Submission Form

Epping to Thornleigh Third Track Proposal. Application number SSI 5132.

Figure 5.6 Cross-section and elevation - New Cheltenham Station concourse building
Note: Indicatively added to future design

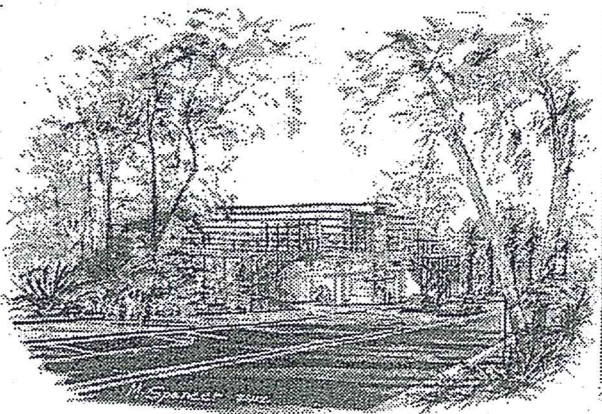
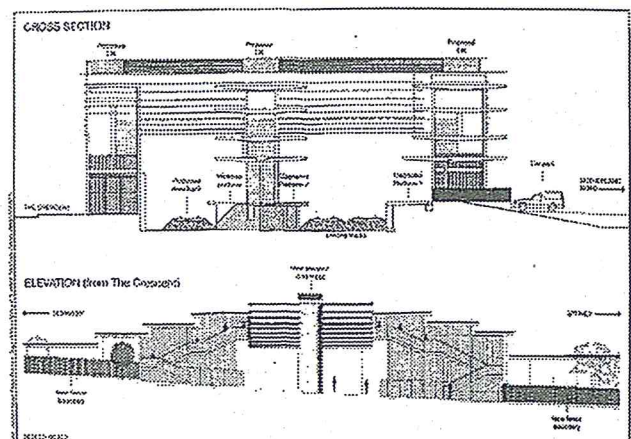
- The proposed redevelopment of Cheltenham Station shows no regard for the HCA. The visual impact of the proposed 13m high glass and steel concourse is totally unacceptable in this HCA.

Concept design drawing of proposed changes to Beecroft Station (Parsons Brinckerhoff 9/3/12). Former side platform shaded in pink.

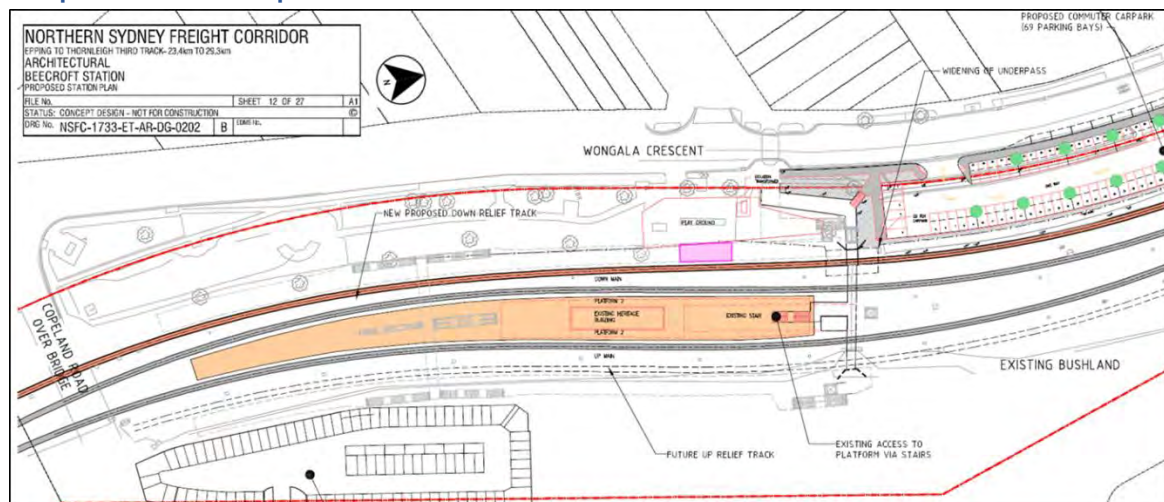
- There has been inadequate assessment of the project's impact on the fabric of the Beecroft Cheltenham Heritage Conservation Area (HCA).
- The plan given for Beecroft Railway station Precinct is vague. The relationship to the trees, playground and original 1895 platform located south of the present station is not shown. A fourth track is shown on the eastern side. The plan does not include urgently needed lifts to allow disabled access at Beecroft Station.

- Beecroft Station Gardens have a heritage listing with Hornsby Council but the impact on them has not been adequately addressed. No arborist's report is given for the trees which will be removed.
